**From:** Charles Wood [REDACTED]  
**Sent:** 03 February 2026 14:24  
**To:** Rhiannon Lloyd <Rhiannon.Lloyd@arun.gov.uk>  
**Cc:** Planning.Responses <Planning.Responses@arun.gov.uk>; Planning <Planning@arun.gov.uk>  
**Subject:** Objection to planning application M/98/25/HH

The following is my objection to certain parts of the planning permission **M/98/25/HH** which follows enforcement case **ENF/328/24** following refusal and dismissed appeal of **M/100/24/HH** which will support the document sent by the other immediate neighbours at 2 Elmer Court.

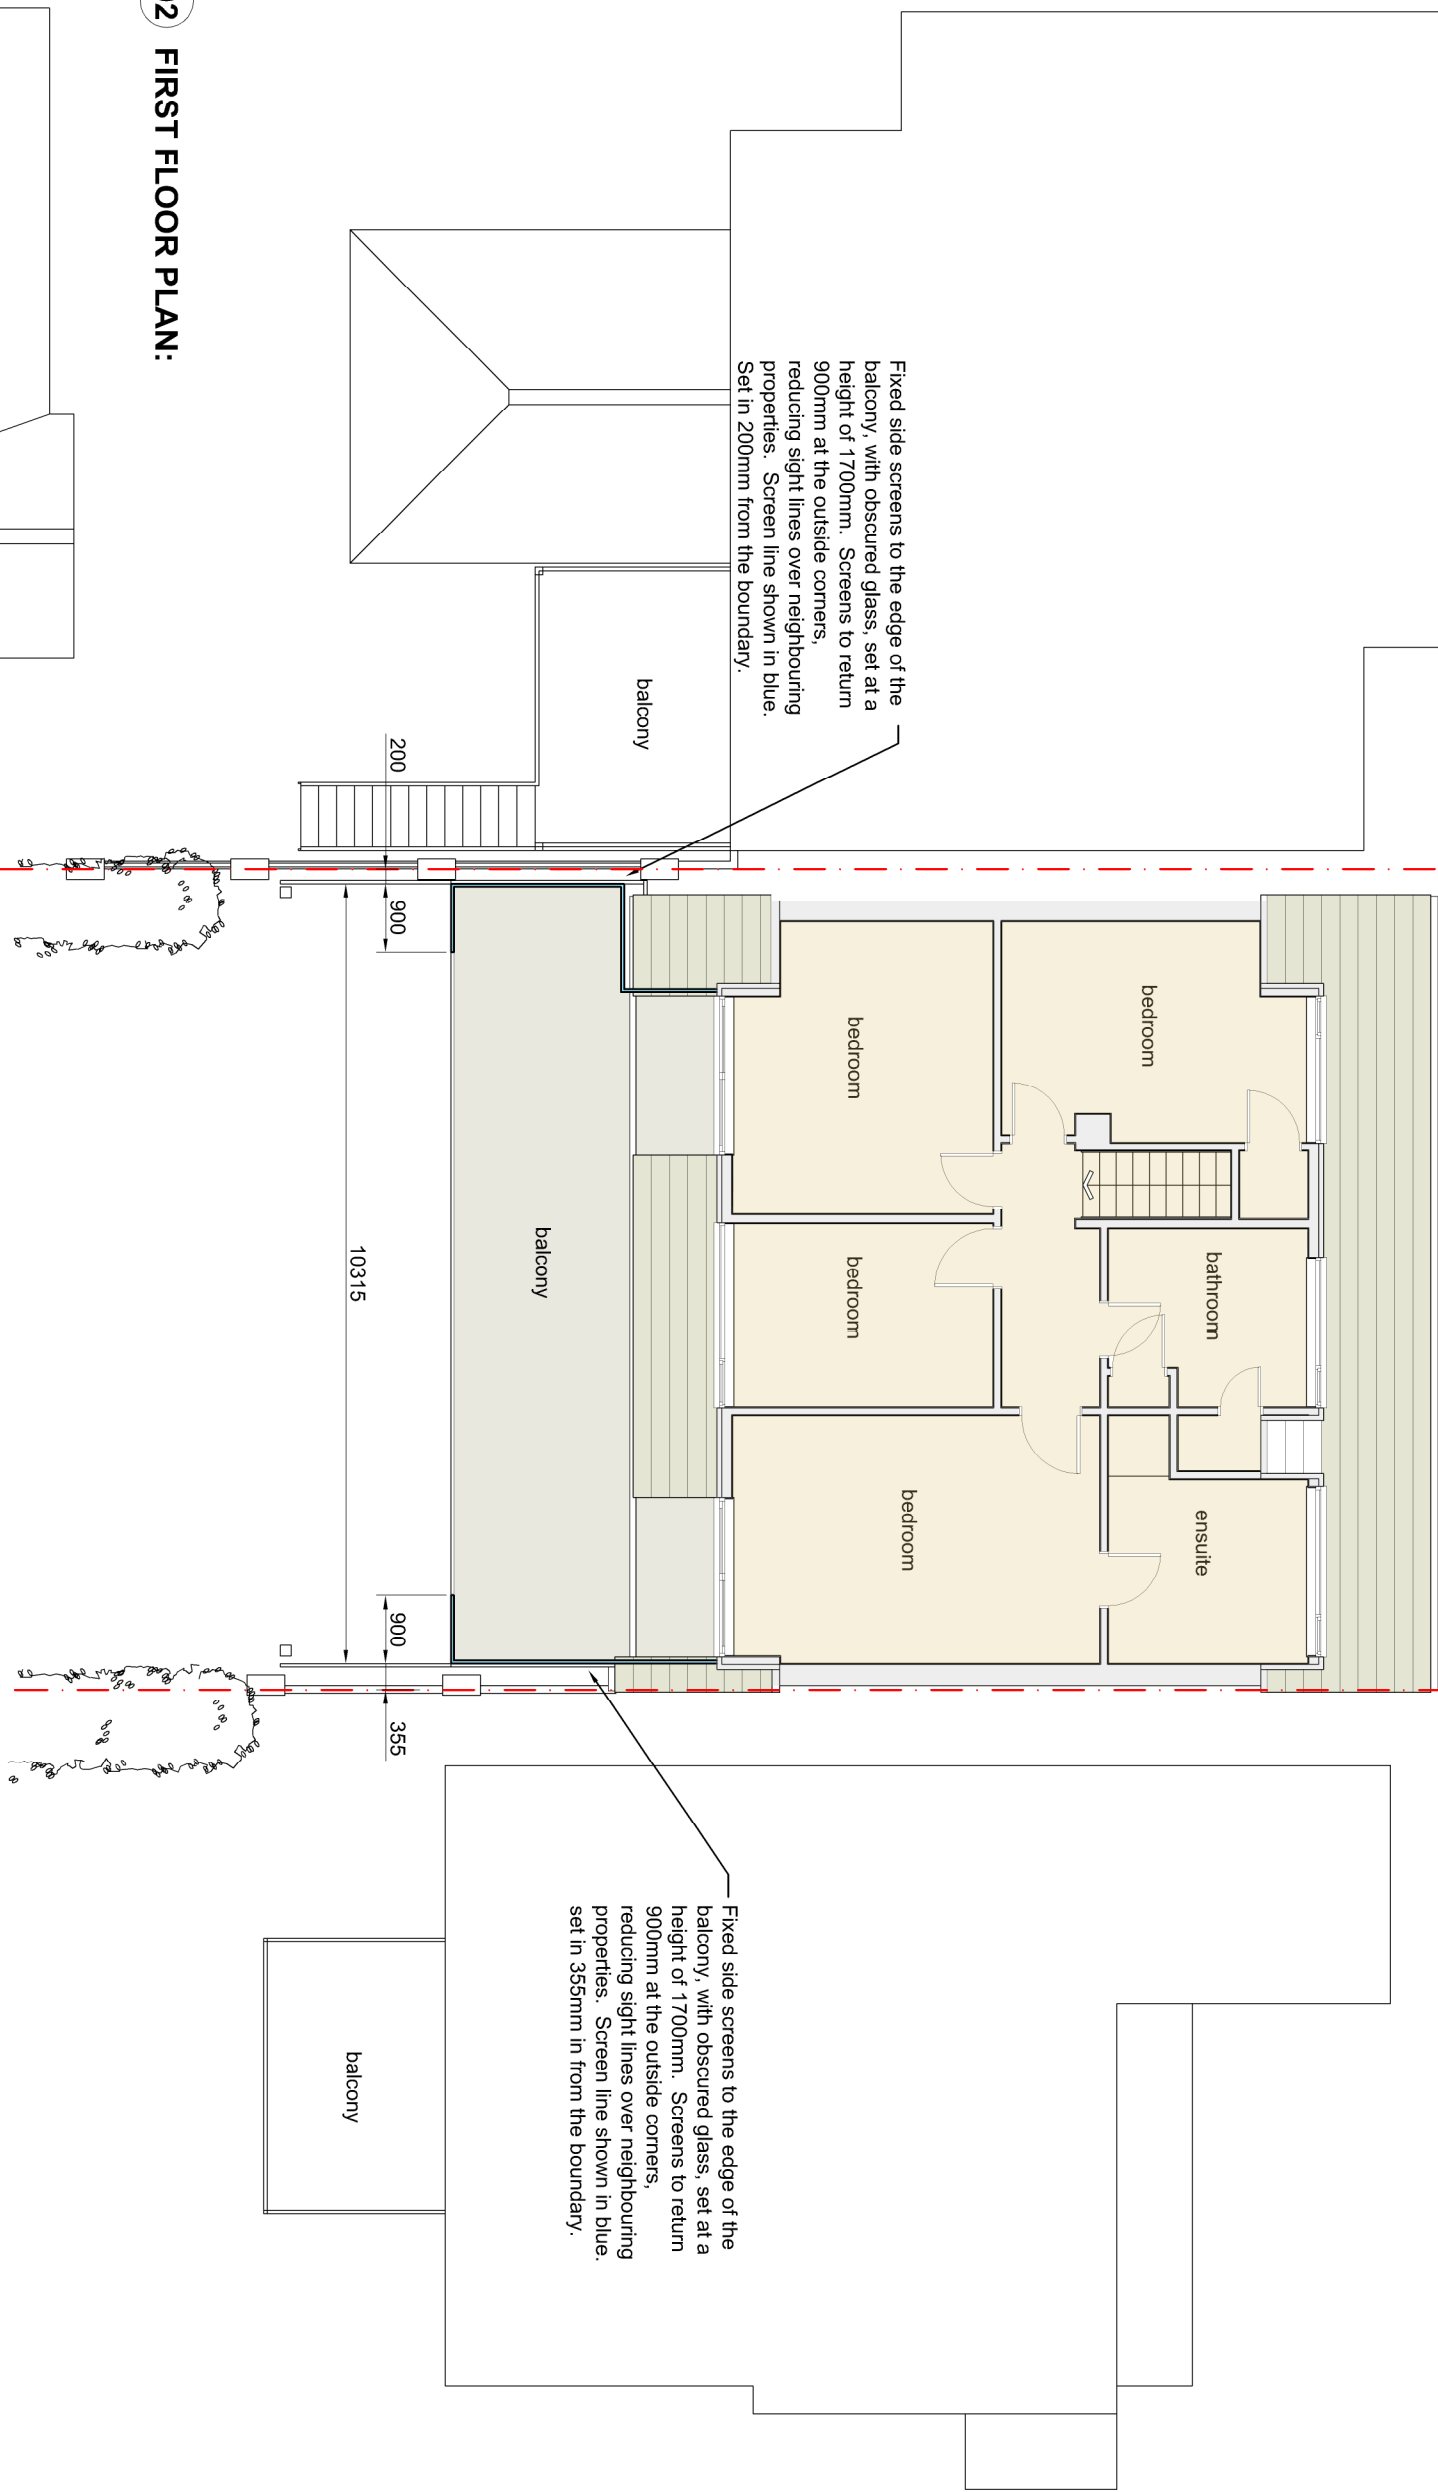
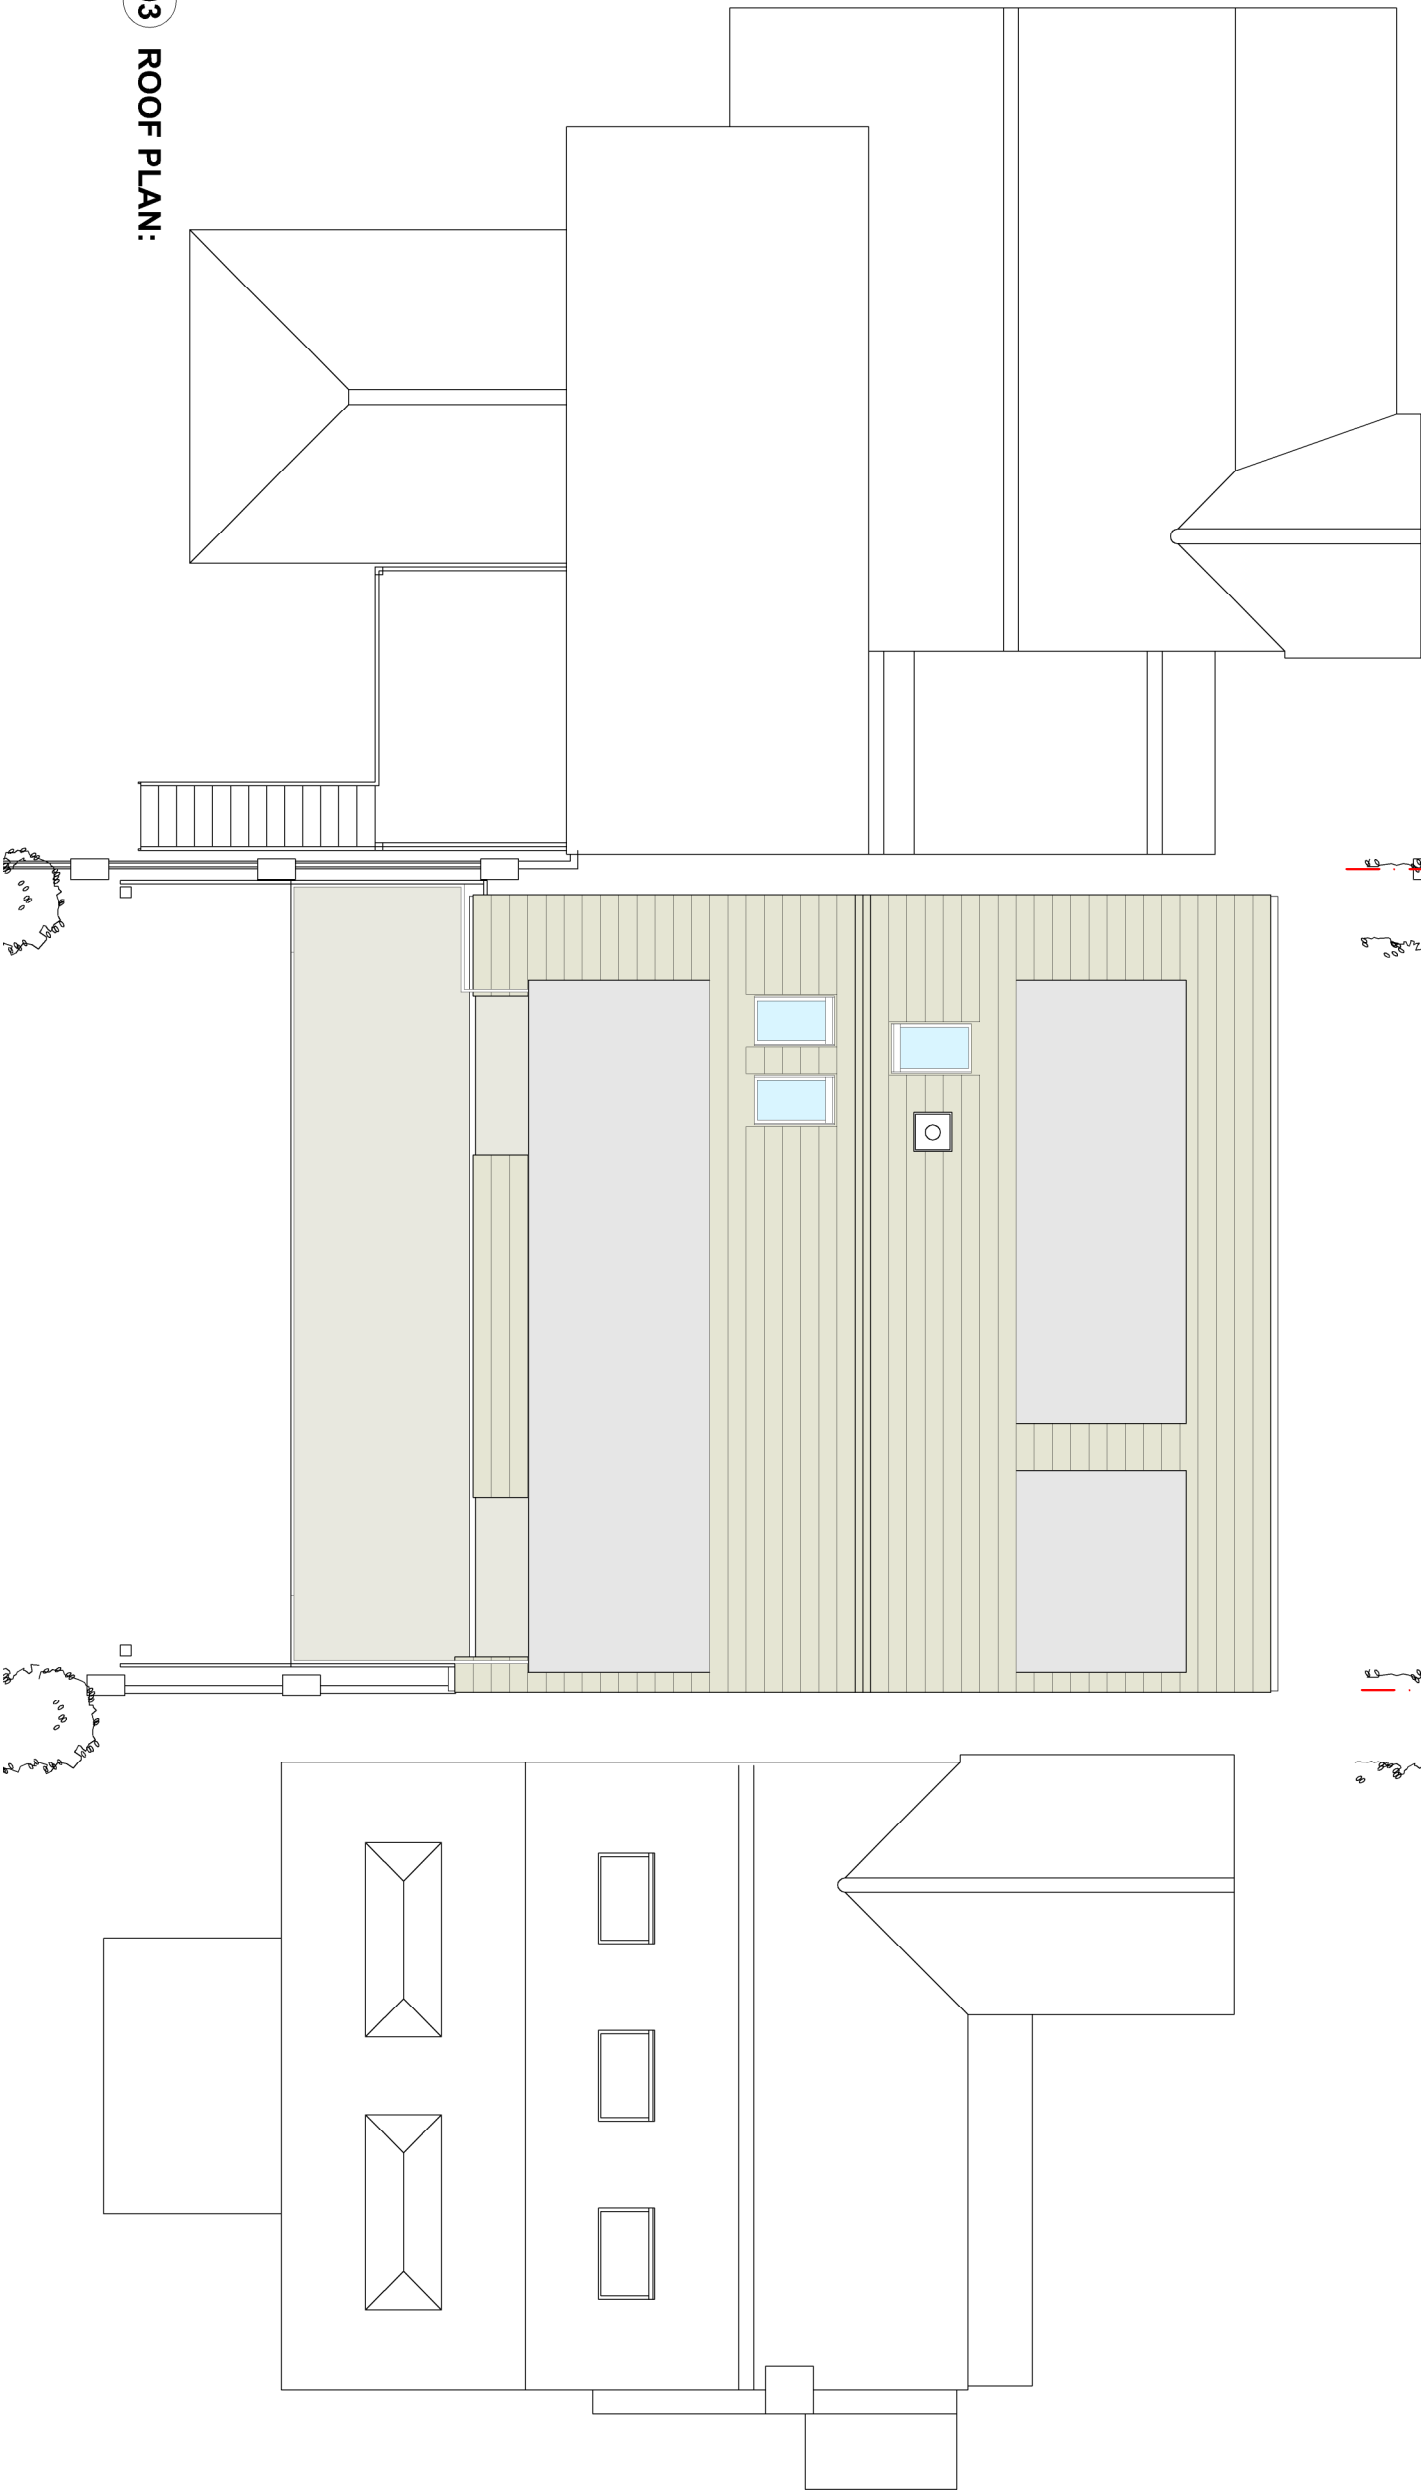
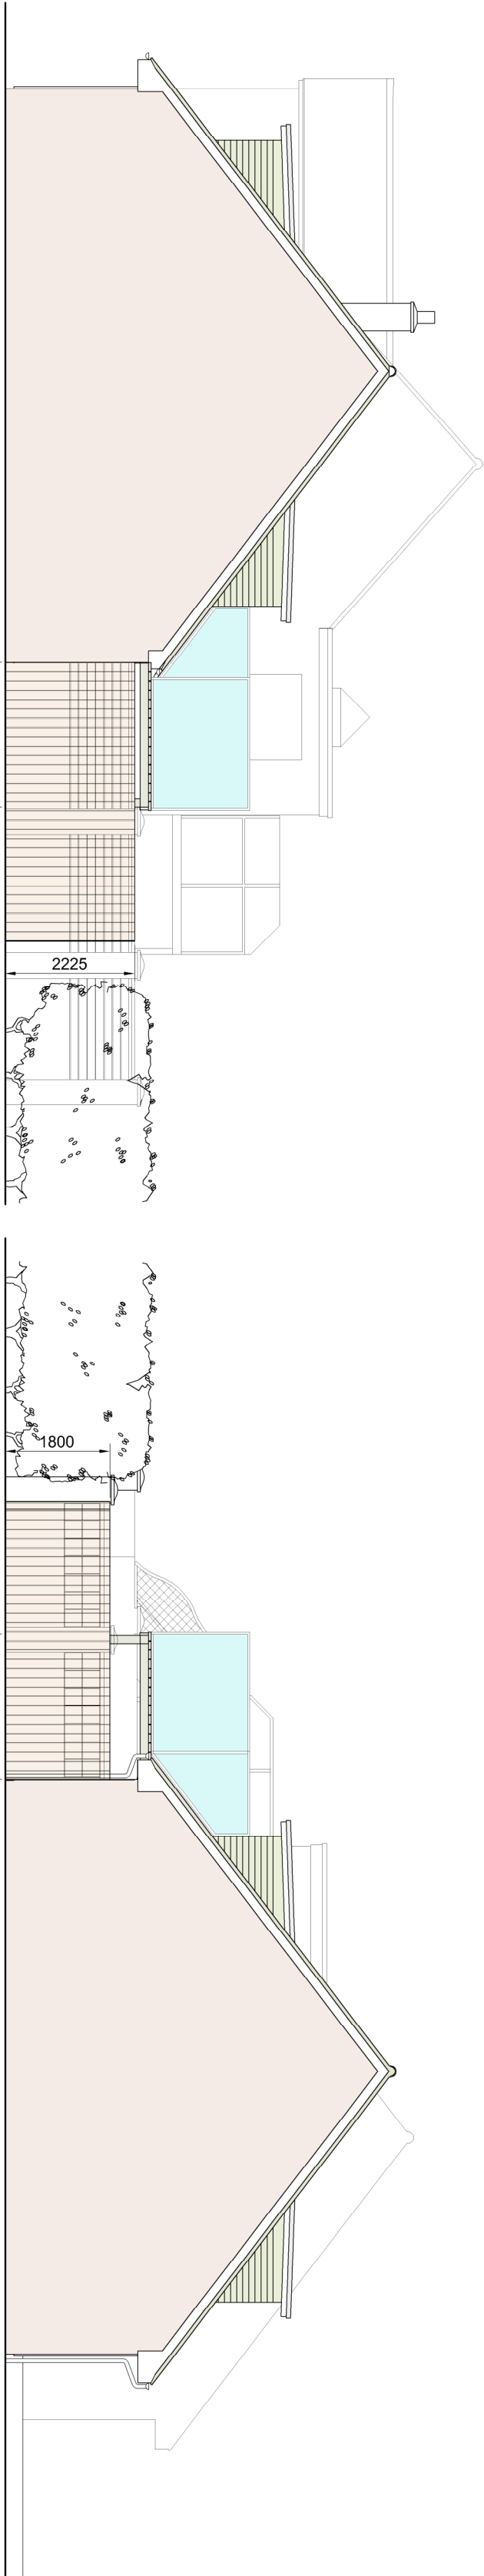
There are considerable inconsistencies in the stated width of the balcony in question and I cannot see in the plans that there is any intention to reduce this width from that which currently pertains and which was rejected by the council when a planning application was previously submitted.

However, the modified plans from the “2024 scheme” refused by Arun and dismissed on Appeal by the Inspector appointed by The Secretary of State, are minor and do not address the reasons for refusal. In fact, the width of the proposed balcony area is unchanged and its structure continuing to be the entire width of the applicant’s property (boundary to boundary) completely overwhelms the rear of the property contrary to Arun policy D DM1.

While it is to be welcomed that the depth of the so called “Pergola” extension has been reduced to a more acceptable level of 2500mm from the previously refused application, the width of the balcony adjoining both neighbouring properties remains unacceptable due to privacy (overlooking) and noise issues. This was one of a number of key reasons that Arun Council refused planning permission and the Planning Inspector dismissed the appeal, so therefore the proposed width (boundary to boundary) being unchanged remains unacceptable and contrary to the decision of the Planning Inspector.

In this case the gaps between No.4 The Hard, 1, Elmer Court and 2, Elmer Court are indeed “relatively small”, and as the balcony is at first floor level it fails the test, “*any extension or alteration at first floor level does not come to within a minimum of one metre of the side boundary*”.

In addition, the height including the substantial metal and glass side screens will be 4.50 meters built at the boundary maintaining overshadowing and overbearing as identified by the Arun Planning officer in their refusal and appeal dismissed by the planning Inspector.

It appears that to attempt to mitigate and overcome this restriction, the applicant is proposing obscured glass privacy screens. The installation of these screens is not a substitute to reducing the width of the balcony to no closer than 1 meter from the boundaries. By their nature, balconies encourage prolonged outdoor use at height, increasing noise levels and disturbance, particularly during evenings and weekends, to the detriment of neighbouring residents. Lack of privacy and considerable overlooking will remain at an unacceptable level. Users of the balcony will be directly overhead of the side garden of 4 The Hard eliminating the previous privacy this area enjoyed. Although these nuisances cannot be entirely eliminated, increasing the distance from the boundary is essential as the proposed 900mm “return” privacy panel to each side of the balcony is an entirely inadequate size to prevent close overlooking of neighbouring gardens

We therefore call for either refusal on basis of unchanged size of the balcony, or revised plans be submitted with the balcony set back from the boundaries. We respectfully suggest that the decision of the Inspector appointed by the Secretary of State should stand and not overruled as the proposed modifications do not meet their concerns or reason for the appeal dismissal.
